**Consultation Response from Mike Hibbert,
KC Waste Strategy(Refuse & Recycling)**

2024/90109 Buxton House, New Street, Huddersfield, HD1 2PJ

Date Responded: 03/04/2024.

Responding Ref: WPS 24-018

Figure 4 First floor general arrangement

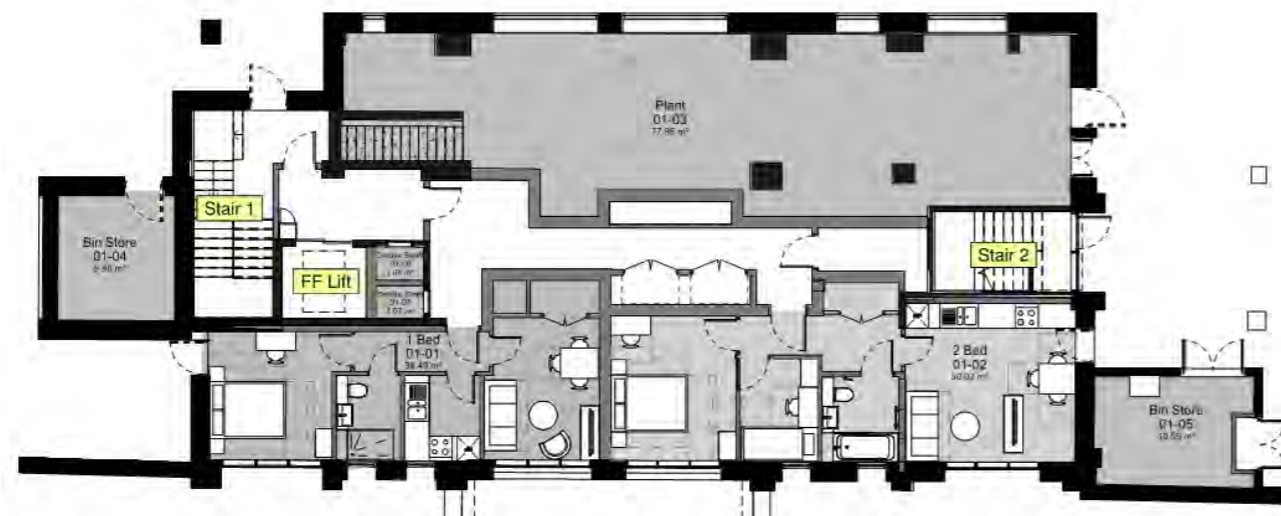
The layout drawing shows the location of two Refuse stores, an existing to the north and a new store to the south.

- For 46 apartments the recommended waste storage provision of 9760 ltrs for both residual and recycling bins. Appropriate waste storage provision would be 14 x 1100ltr wheeliebins (7x Recycling and 7x residual). It may be unrealistic to store this number of bins. The applicant may have baseline data from the existing flats other similar developments that can be used to refine the likely waste arisings.

- Guidance indicates the floor space for a 1100ltr wheeliebins is 1575mmx1190mm with space to manoeuvre the bins within the store. Appropriate standards are detailed in the Kirklees Waste Management Design Guide 2020. Bin store surfaces should be durable and waterproof enough to withstand heavy duty cleaning such as power washing.

- It is not clear if the Concierge service will be responsible for collecting waste from residents and transferring to the bin store or if residents will deliver their own waste. The walk distance from the entrance points of the block to proposed bin store(s) should be no more than the 30m as specified in guidance BS5906:2005 and this appears to be acceptable on the plan.

- Bin storage presents a fire risk. Guidance indicates communal bin stores should be 6m from buildings unless designed to comply with fire regulations (refer to BS 5906:2005 Waste Management in Buildings; Building Regs 2010 Part H6 and CFPA-E Guideline No 7:2022 F).

- The waste store should be secure to prevent theft, unauthorised use/ fly tipping or rough sleeping. There will need to be appropriate lighting in and around the store areas. If the doors to the bin stores are to have a keypad to secure access these details will be required by the collection staff.

- The WCA currently collects waste from Buxton House.
- Consideration should be given to weight limits when accessing the first-floor deck with a fully laden RCV (approximately 26 tonnes)
